Sent: 08 September 2009 12:29
To: Planning
Subject: Planning application S6/2008/2456/AD - 8 Parkhouse Court

Response to Planning application from Hertfordshire County Council (T and CP GDP Order 1995)

Location
8 Parkhouse Court
Hatfield
AL10 9RQ

Proposal
Installation of internally illuminated fascia sign and internally illuminated projecting sign

PROPOSED SIDE ELEVATION

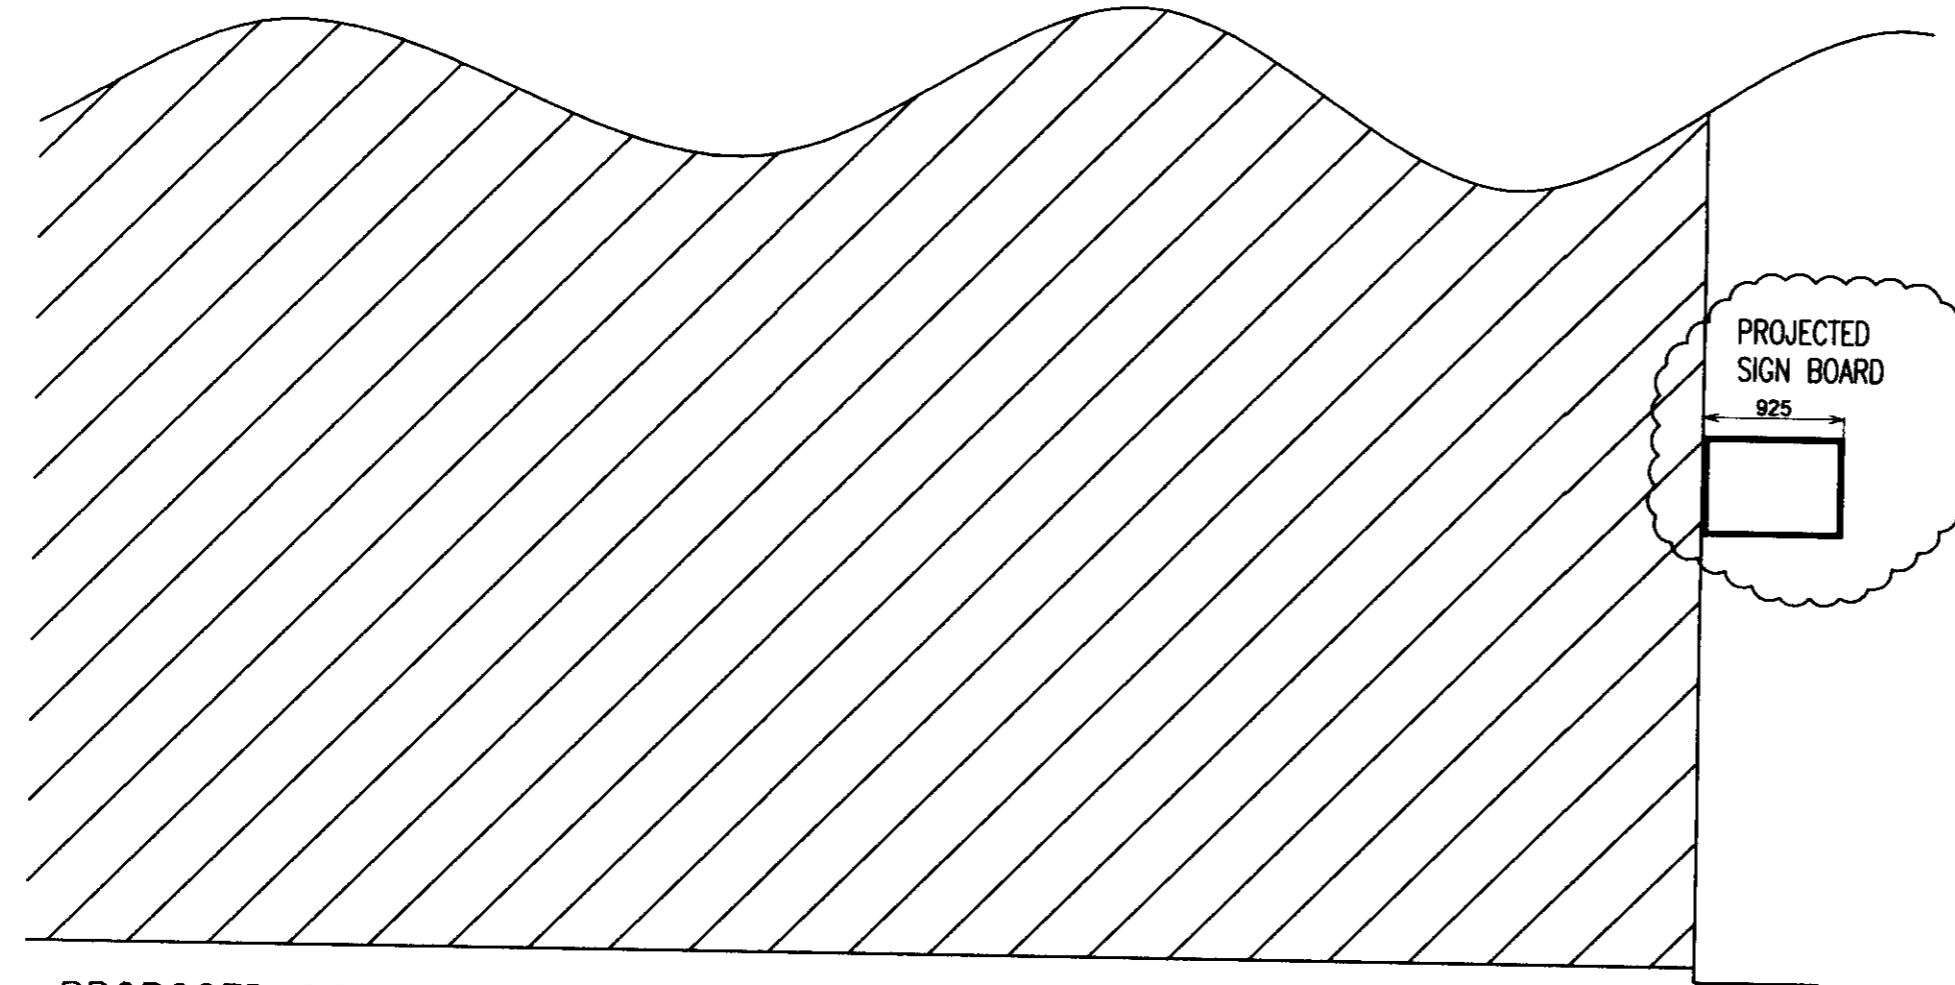
The proposed signage is not on the highway and therefore has no implication on highway safety. However I would recommend that a condition regarding height is added to protect pedestrians using this area.

1. All parts of the projecting signage must be at a height of, or greater than 2.3 m vertically above the footpath and no less than 500 mm horizontally from the edge of the carriageway. Reason: In the interests of pedestrian safety and convenience
